From: Brian Elstone [REDACTED]
Sent: 28 February 2022 15:22
To: planning.responses@arun.gov.uk
Cc: Iqraa Malik
Subject: RE: Request for further information FG/36/22/HH
Attachments: We sent you safe versions of your files; 1488 - Layouts A3 001 Rev B1.pdf; 156 A259 - Google Maps a.pdf; IMG_2569.jpg

The description – The porch is existing and being built over, as photograph IMG 2569, so maybe just the “Two storey side extension, single storey front extension and new Entrance

Drawing Number: 1488/001 Revision: B1

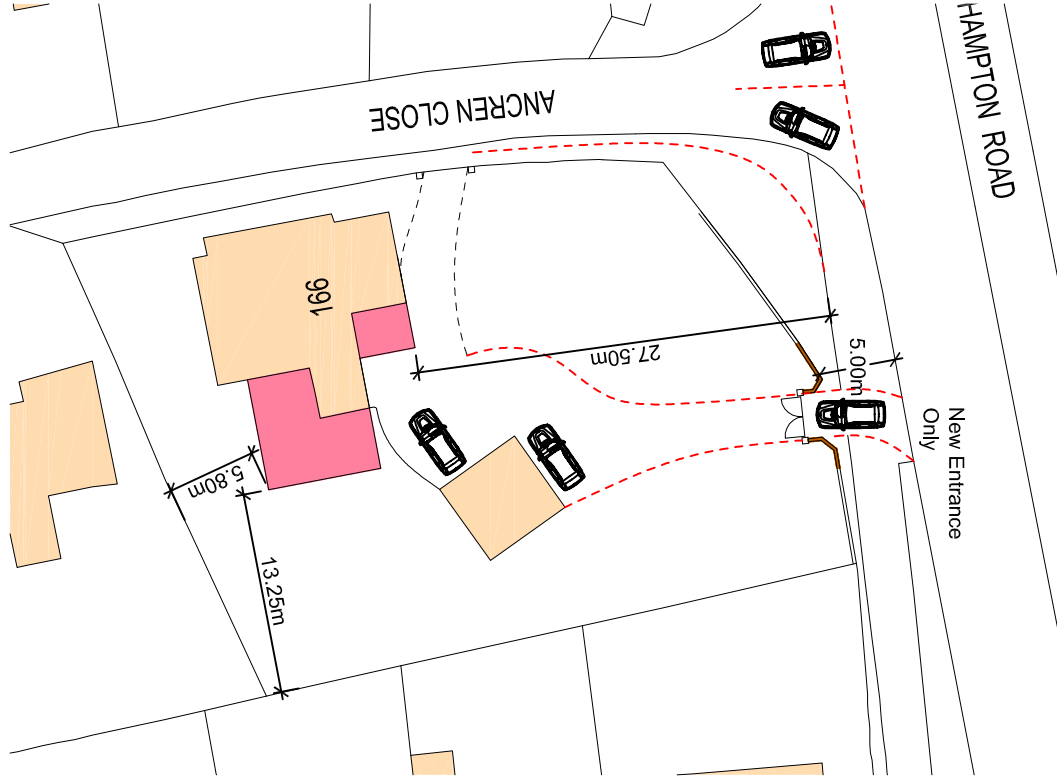
I have revised the proposed site Plan to show 5.0m and attach a photograph of one of the other entrances on this road as the visibility splay aspect does not apply as the new entrance is for access only.
